Address: 46 Station Road Huddersfield HD8 0AD

Application number: 2025/91627	
What is the application for?:	Erection of two storey extension to side and front, balcony to rear and associat
Address of the site or building:	42A, Station Road, Fenay Bridge, Huddersfield, HD8 0AD
Postcode:	HD8 0AD

Type of comment: An objection	
Do you wish your comments to be published on the website anonymously?	No
<p>Please accept my strong OBJECTION to the above planning application.</p> <p>This planning application includes a supporting document prepared by AK Planning, within which there are factually incorrect, therefore misleading statements. For example it states "The extension is hidden well away from any public view, including from neighbours." This is factually incorrect, as I will be able to see the whole of one side of it from the room where I am typing this. It will also be in full view from number 44 Station Road from several window, including habitable rooms.</p> <p>Also stated and hereby contested is "Except for one obscure glazed bathroom window, none of the proposed windows face, at any kind of proximity, towards the neighbours." This is contentious, as the Velux windows will have

Proposed Elevations

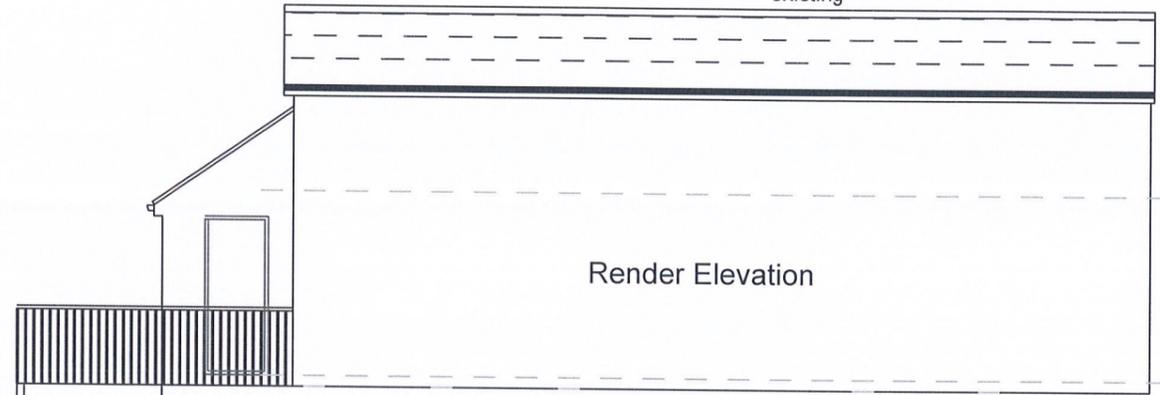
The proposed extension is not subservient to the existing property, having 50% more living space than the existing bungalow (in which the basement isn't lived in). Also, the footprint of the proposed extension is almost 80% of the size of the existing bungalow, which I believe is out of proportion.

The ridge height of the proposed extension is the same height as the existing bungalow, which is not acceptable.

Site Plan & Roof Plan		
Fenay Bridge		
HD8 0AD		
Date	May 2025	Dwg no 05
Scale	A3 - 1:200	
Dwn By	-----

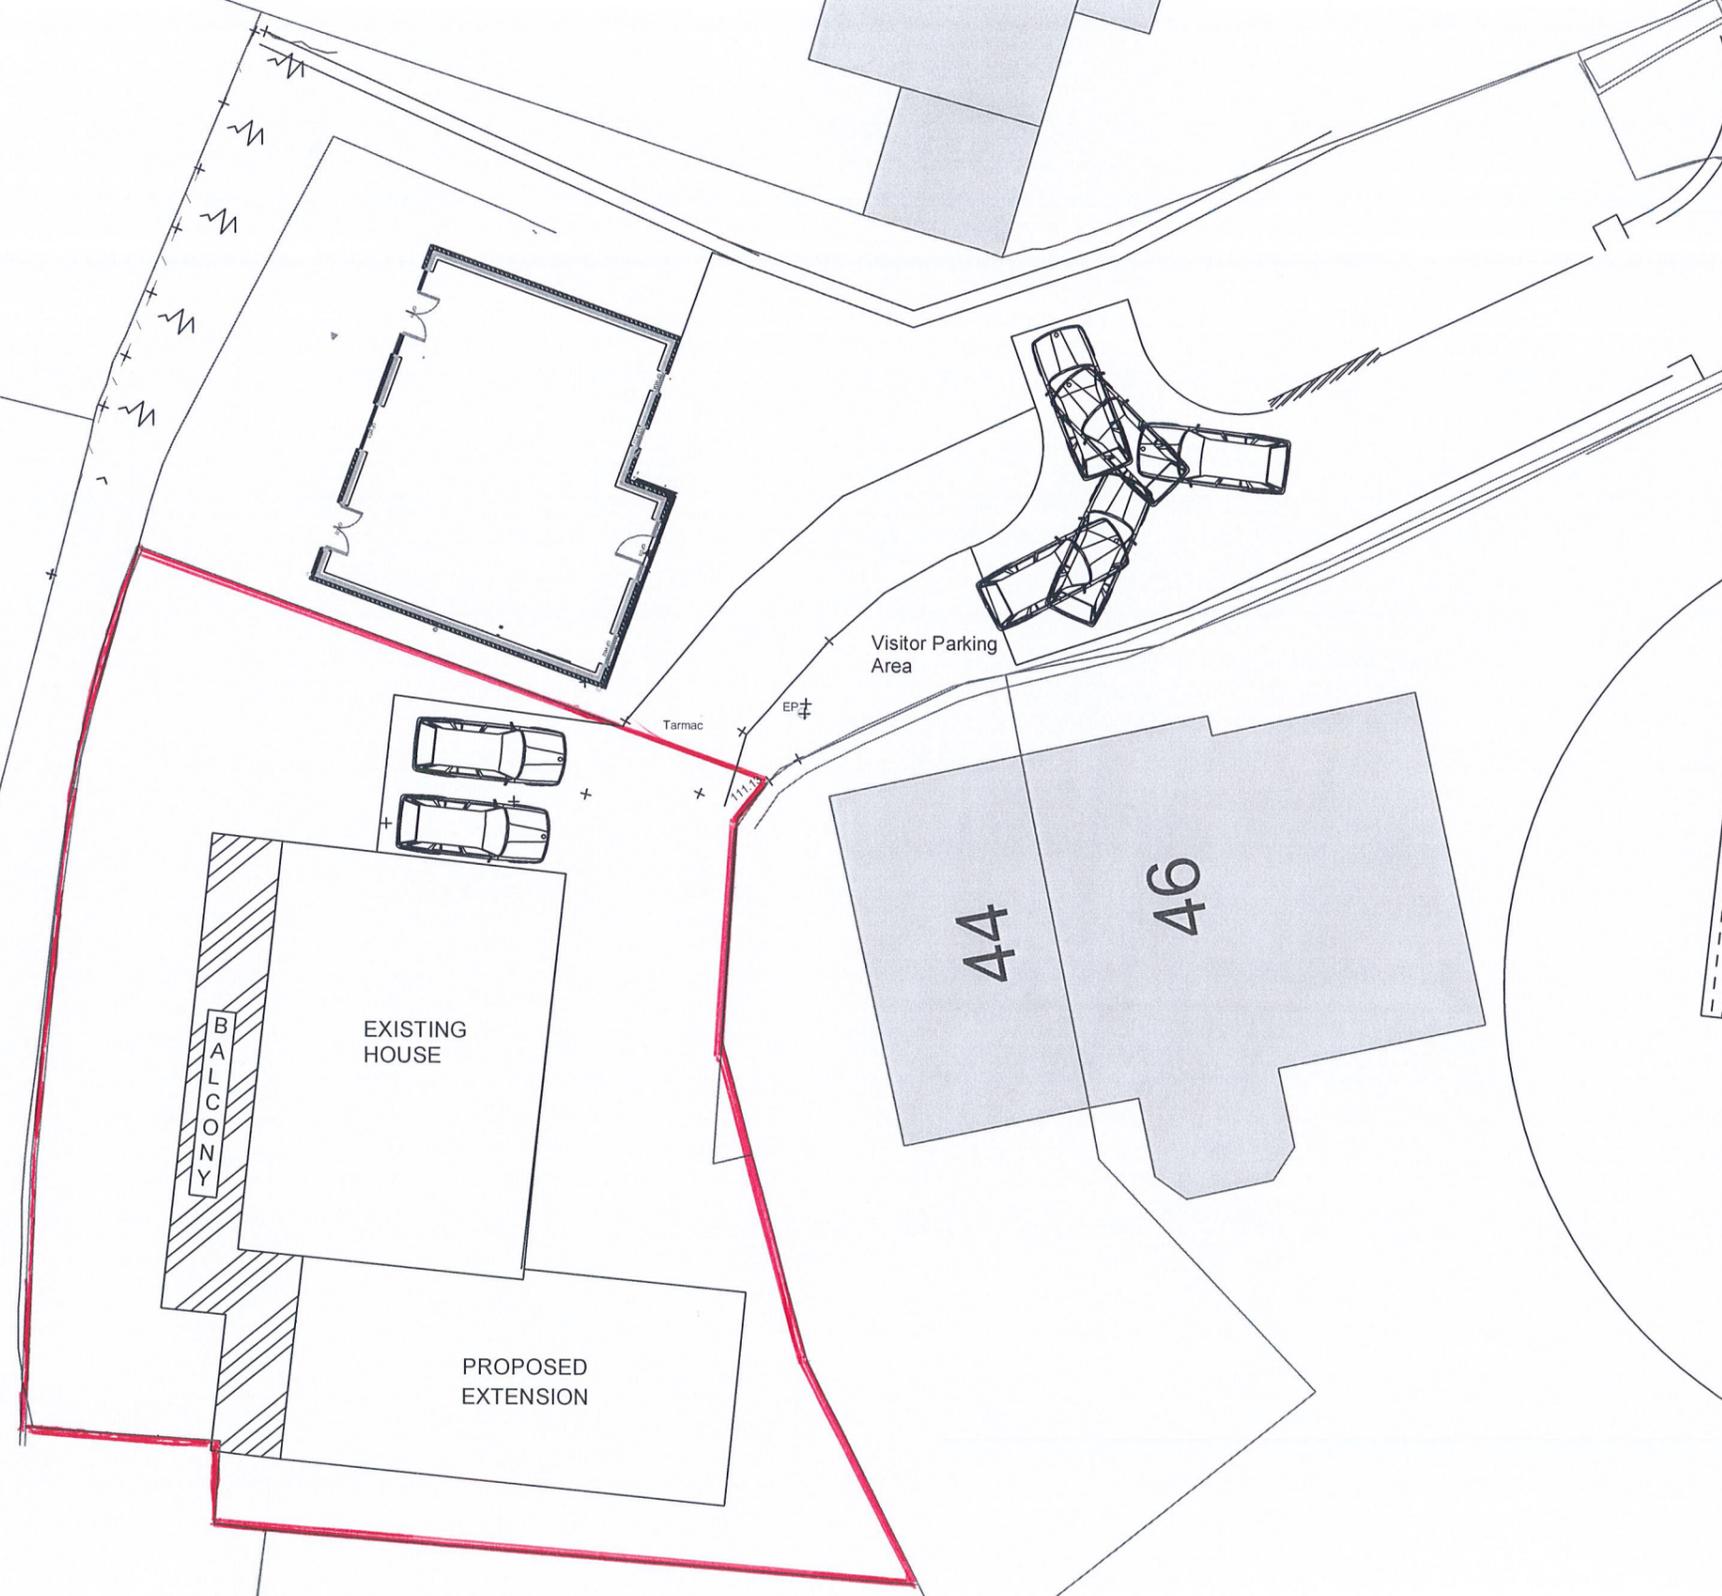
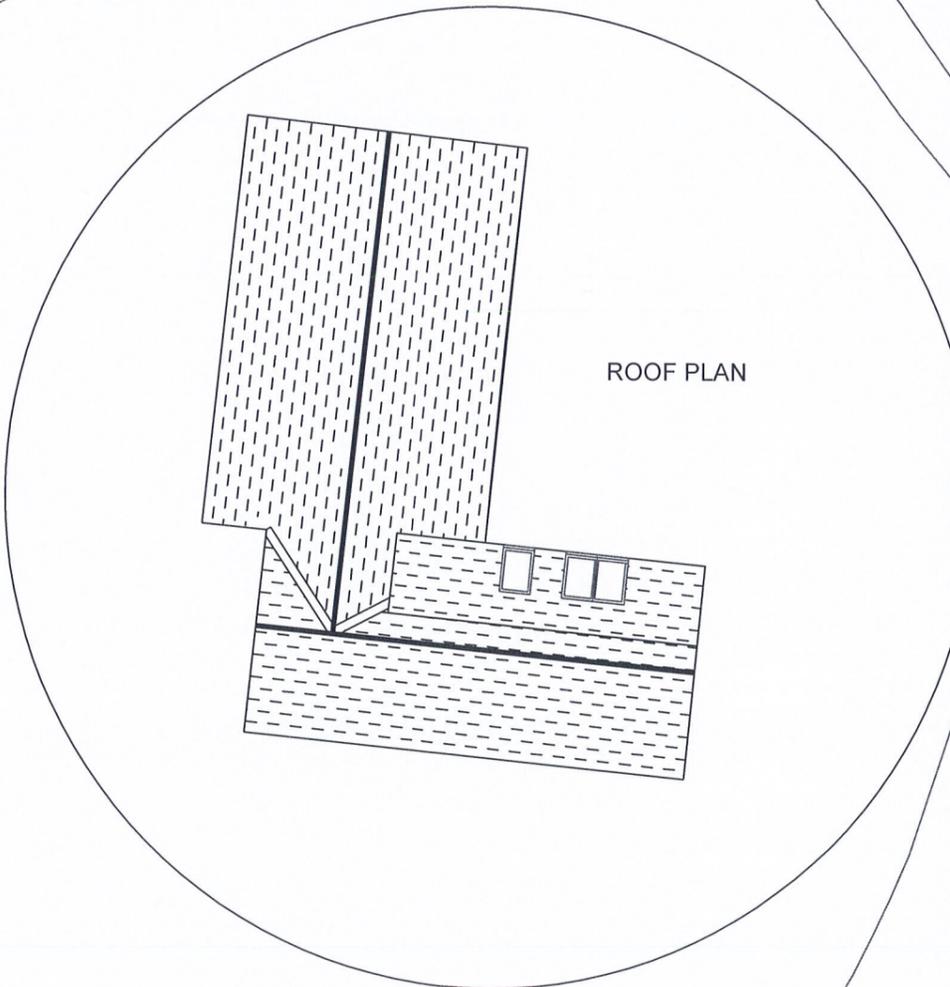
Also, the location plan submitted with this application omits the new detached property, which is misleading and creates a false perception of space in the plot.

Key design principle 7: Outdoor space Extensions and alterations should ensure an appropriately sized and useable area of private outdoor space is retained. Normally at least half the garden area should be retained as part of the proposals.
